Appeal Decision

Appeal Ref: APP/R5510/D/23/3320787

37 Windmill Hill, Ruislip, Hillingdon HA4 8PY

- The appeal is made under section 78 of the Town and Country Planning Act 1990 against a refusal to grant planning permission.
- The appeal is made by Mr Chris Demeester against the decision of the Council of the London Borough of Hillingdon.
- The application Ref 21828/APP/2022/3769 dated 12 December 2022, was refused by notice dated 3 February 2023.
- The development proposed is described as erection of a first floor rear extension and single storey rear extension.

PROPOSED REAR ELEVATION - 1:100

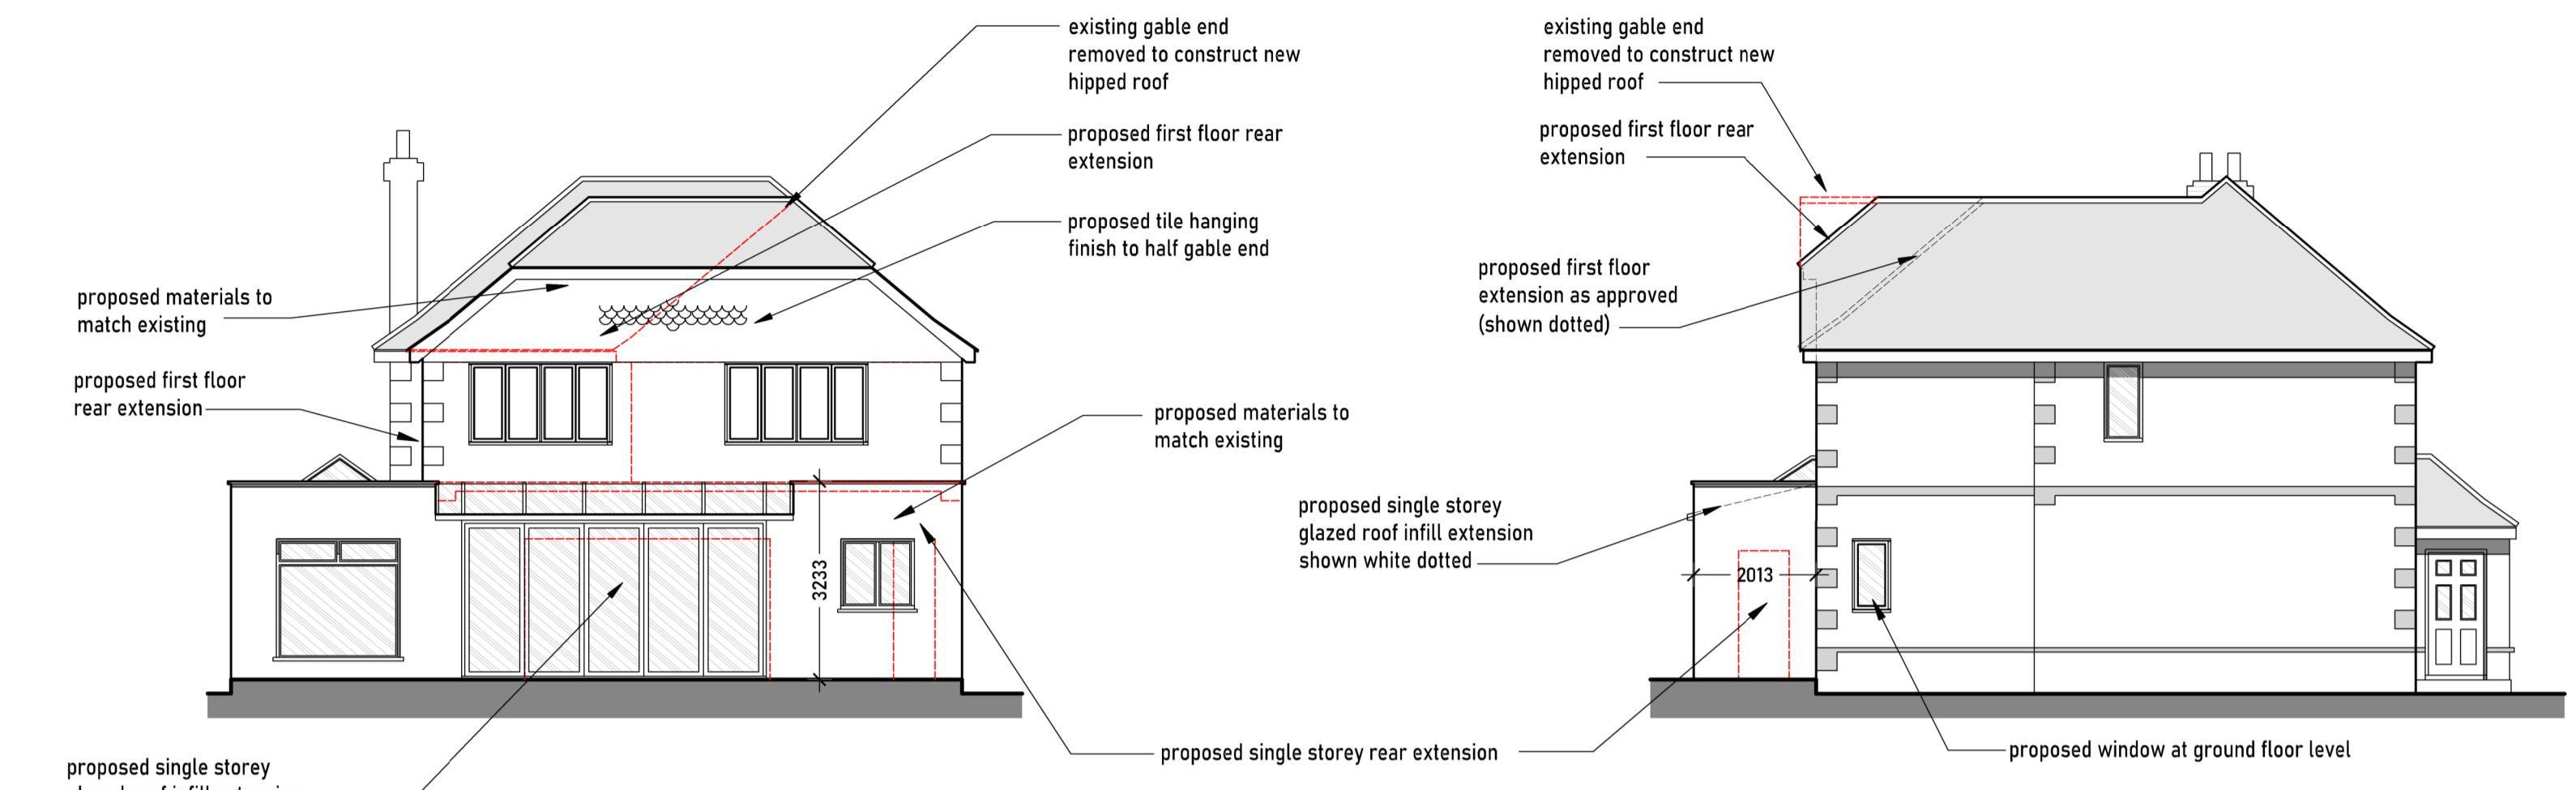
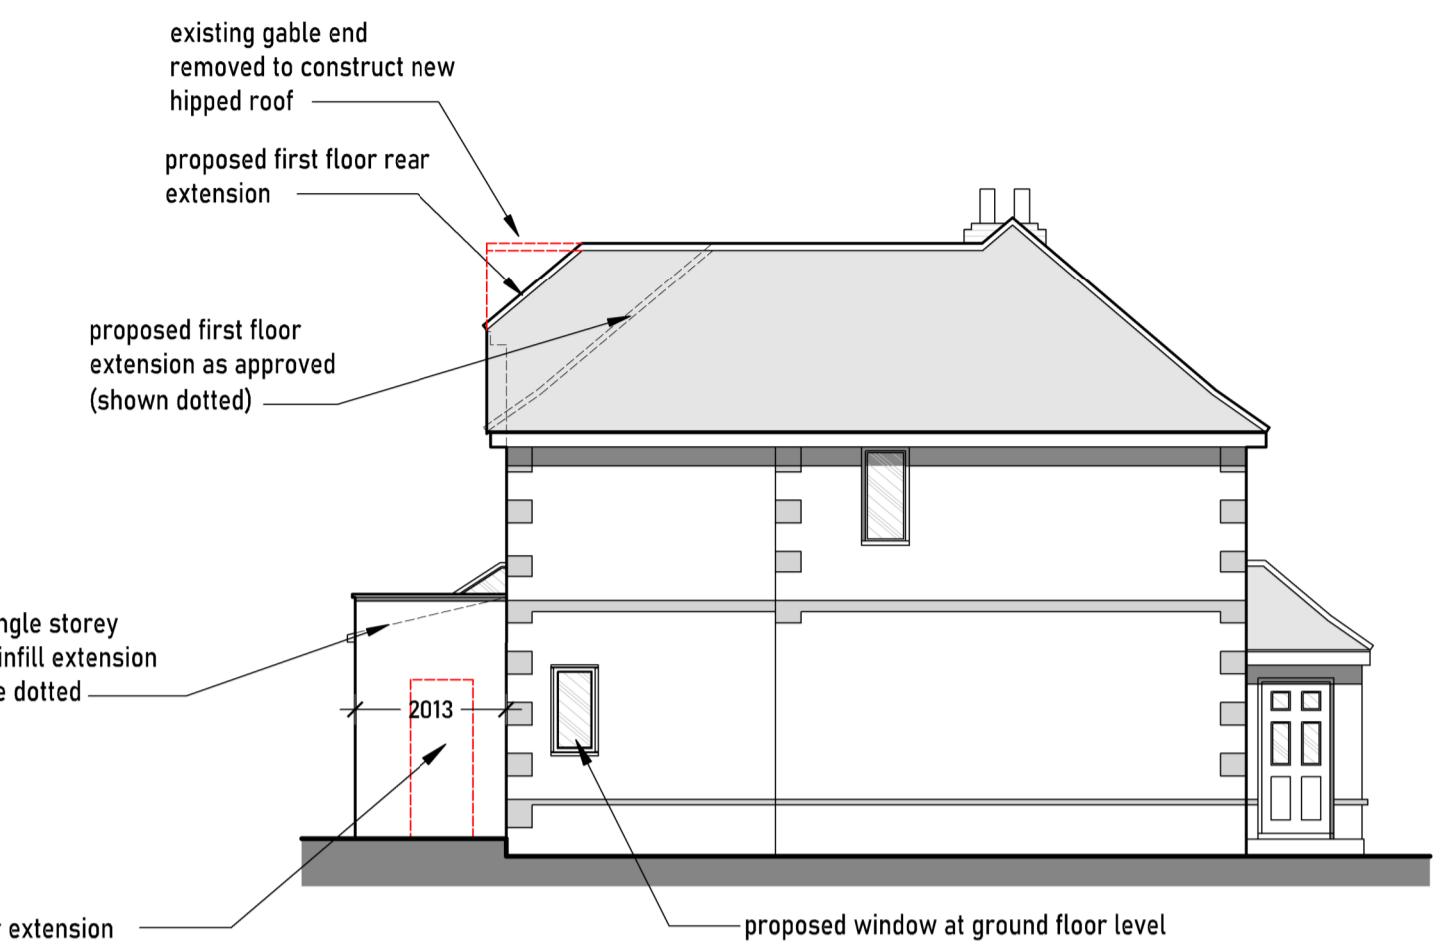
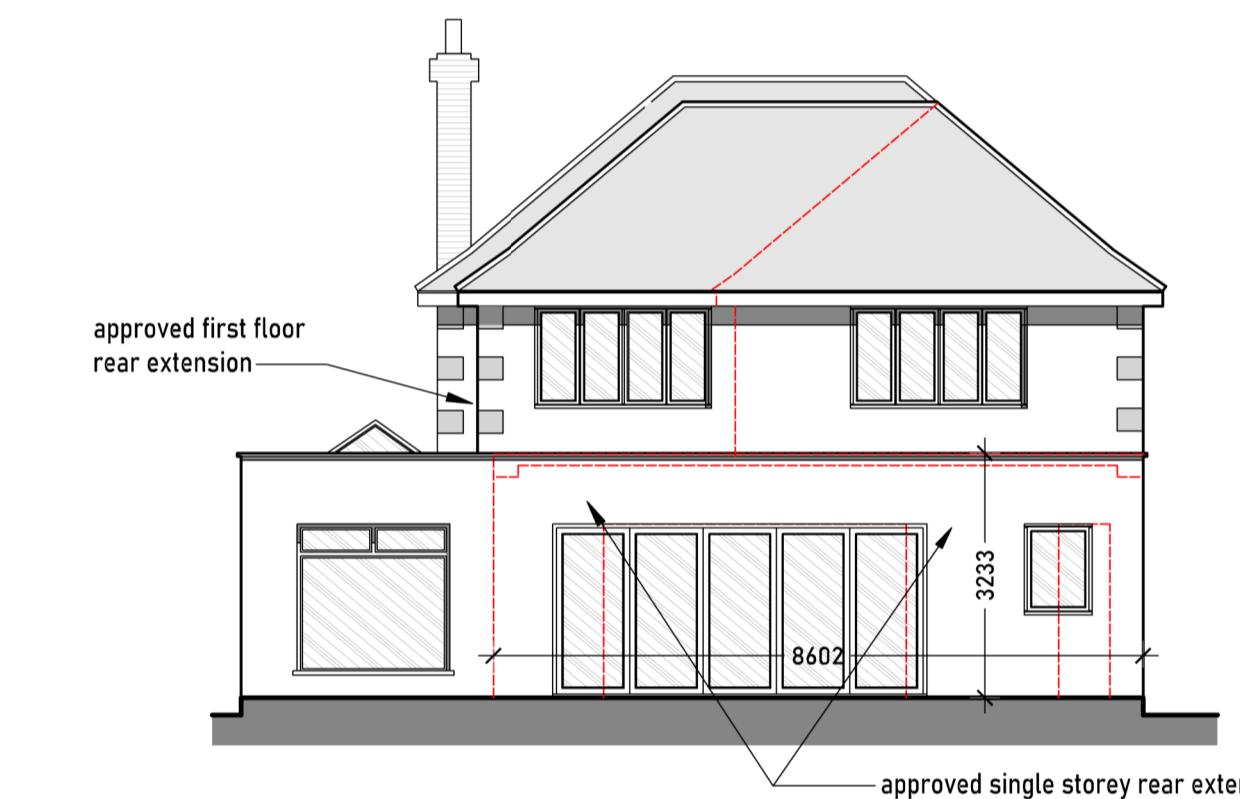
4. The site is a detached property within a predominantly residential area with Ruislip Manor Town Centre to south. Properties in the immediate area vary in terms of design.
5. I understand there is a previous approval¹ for a similar development, the main difference between the approved scheme and the development before me are the roof designs. The revised roof design includes a glazed infill roof above the single storey rear extension and alteration from the approved hipped main roof to the rear to part gable/part hipped.

6. The infill glazed mono pitched roof is unobtrusive in terms of scale and design adding interest to the rear of the property.
7. The material proposed on the submitted drawing differ from that of the as built development, the first floor has been fully rough rendered in a sandstone colour which is not a common colour found in the immediate area, nonetheless I understand this is similar to the materials used on the rear of the appeal property prior to the development. Should the materials noted on the submitted plan be used, for instance hanging tiles, I do not find that this would significantly affect the visual appearance of the property which would warrant refusal.

8. The windows located in the first floor rear elevation are below the eaves of the roof, nevertheless they do not exacerbate the mass of the development. I find that the development is not disproportionate in scale to the appeal site. Whilst I did not observe a similar roof design to that of the development it did not appear incongruous to the existing property or area in general.
